From:
To: [DCAdmin](#)
Subject: Planning Application 2023/90082
Date: 20 February 2023 18:38:46

1 Yew Tree Gardens
Birchencliffe
Huddersfield
HD3 3ZS

Proposed First Floor

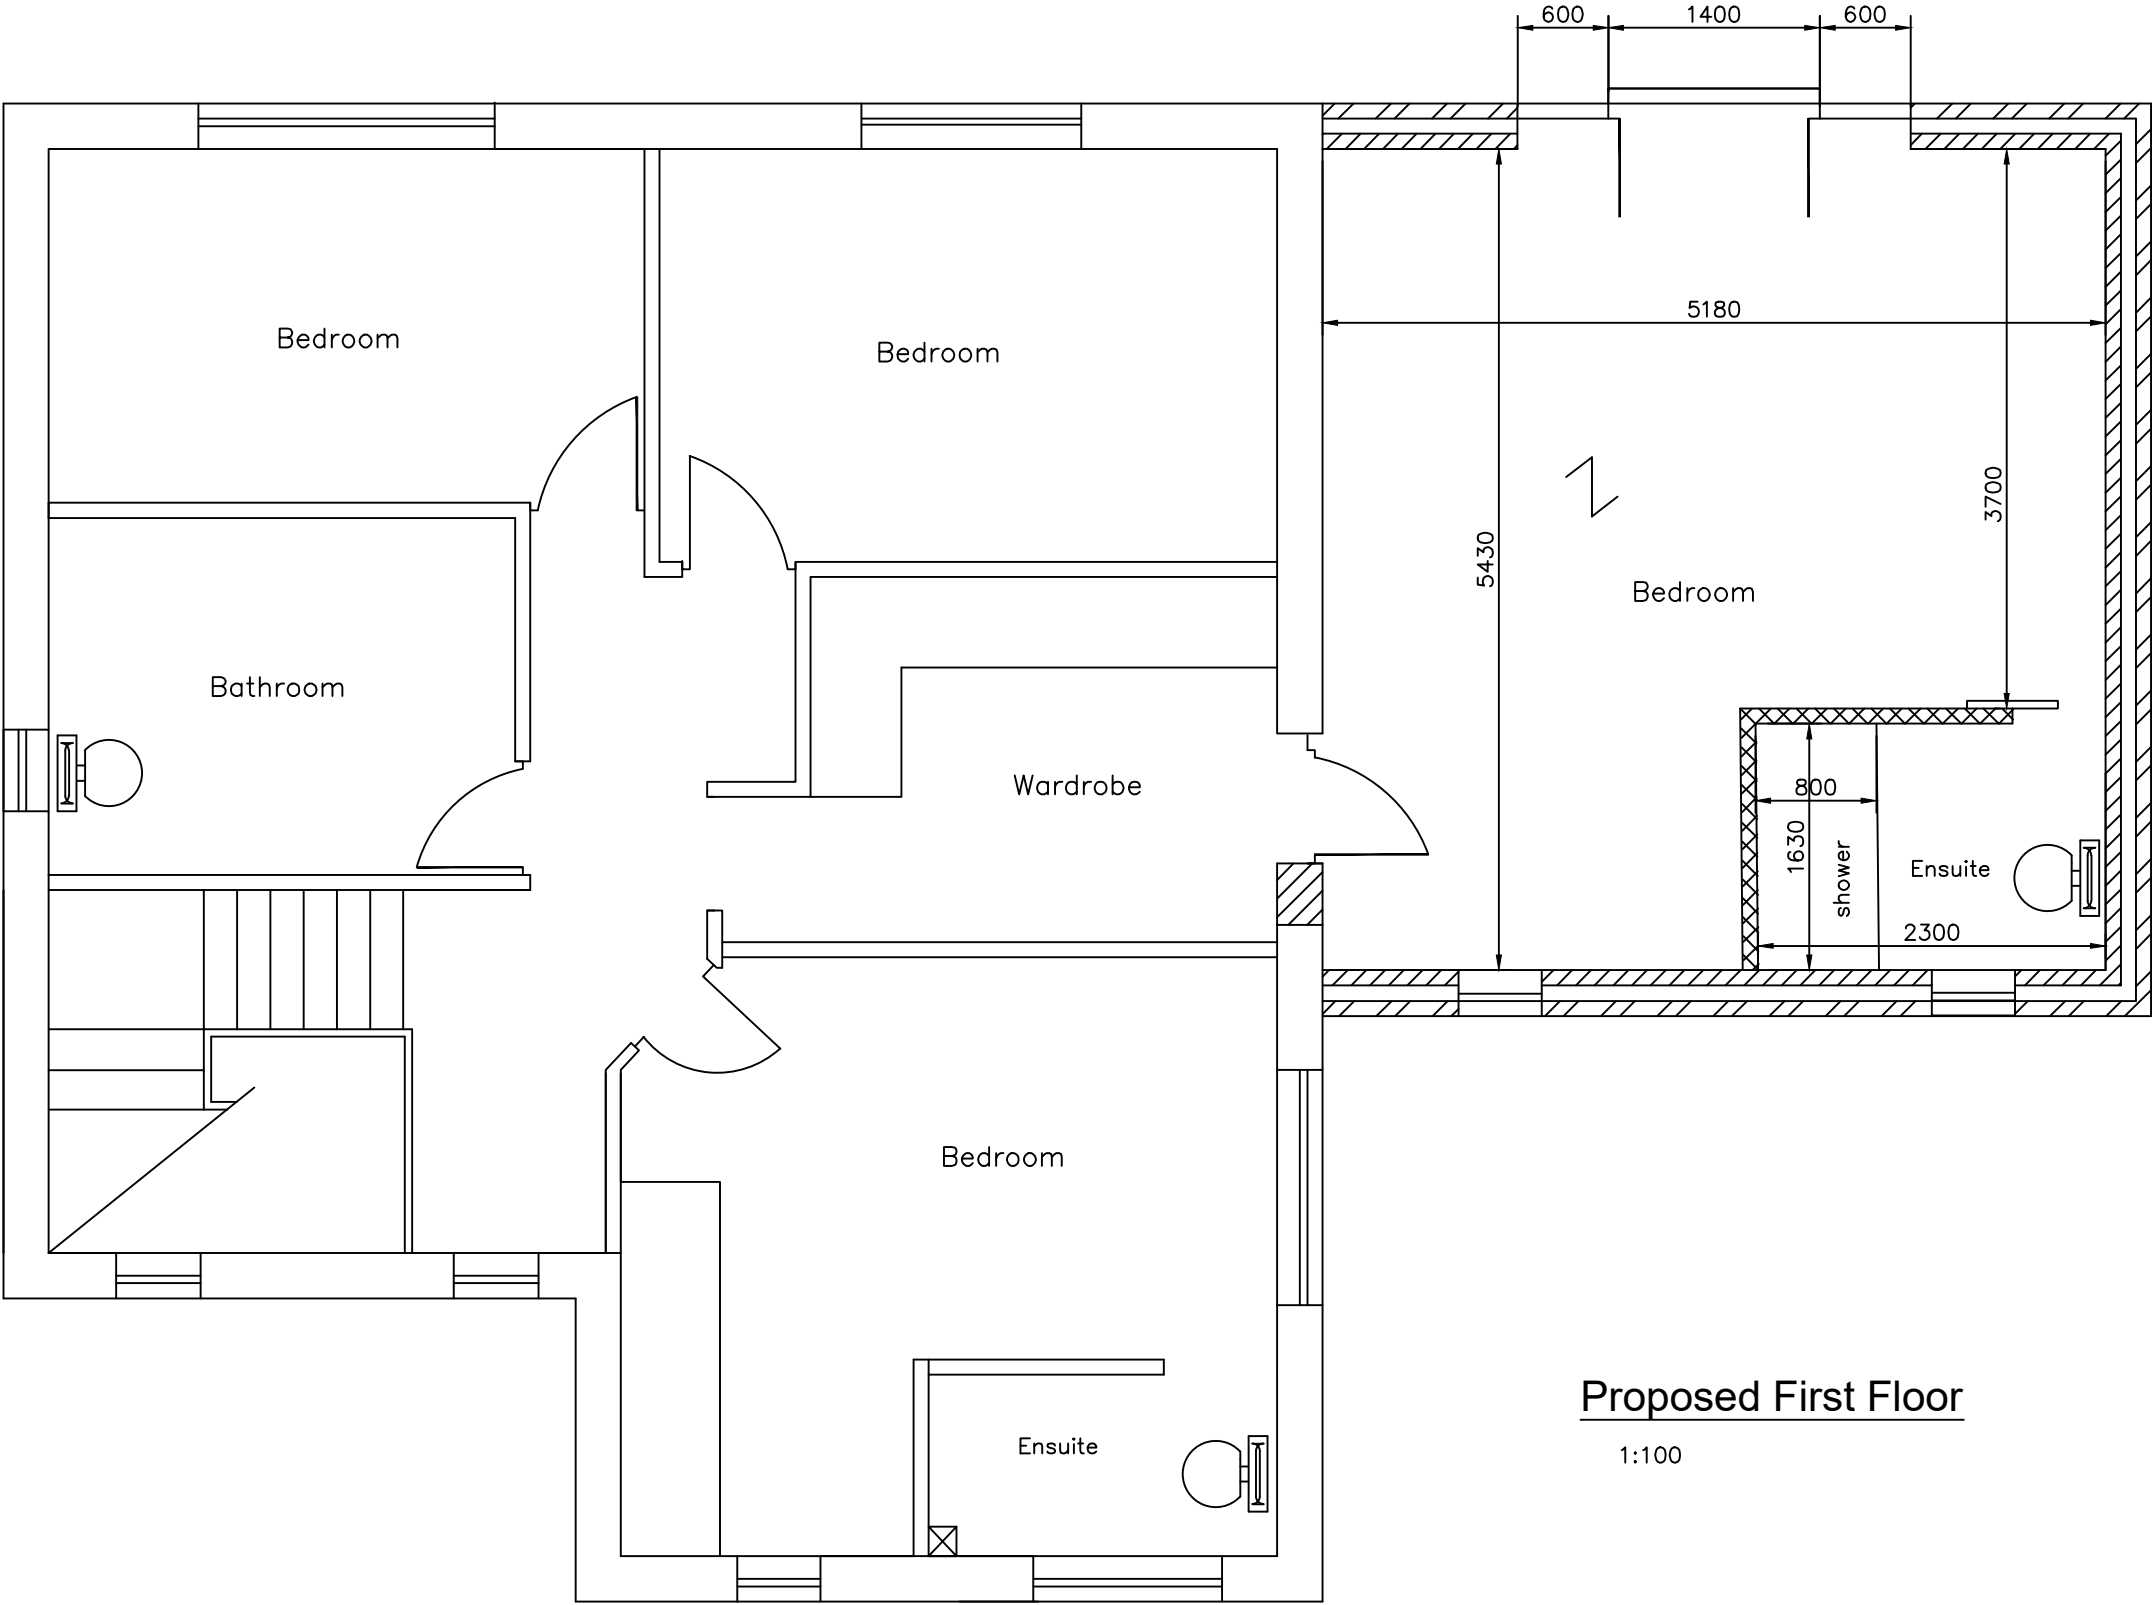
- Our main objection to the proposed first floor extension is the large glass balcony doors and windows to the South side of the extension as these will overlook directly into our bedrooms and garden space, leading to a lack of privacy.
- If an alternative application was to be put forward with the proposed balcony doors and windows relocated to either the West or North side of the building, this would provide less of an intrusion of privacy into neighbouring properties.
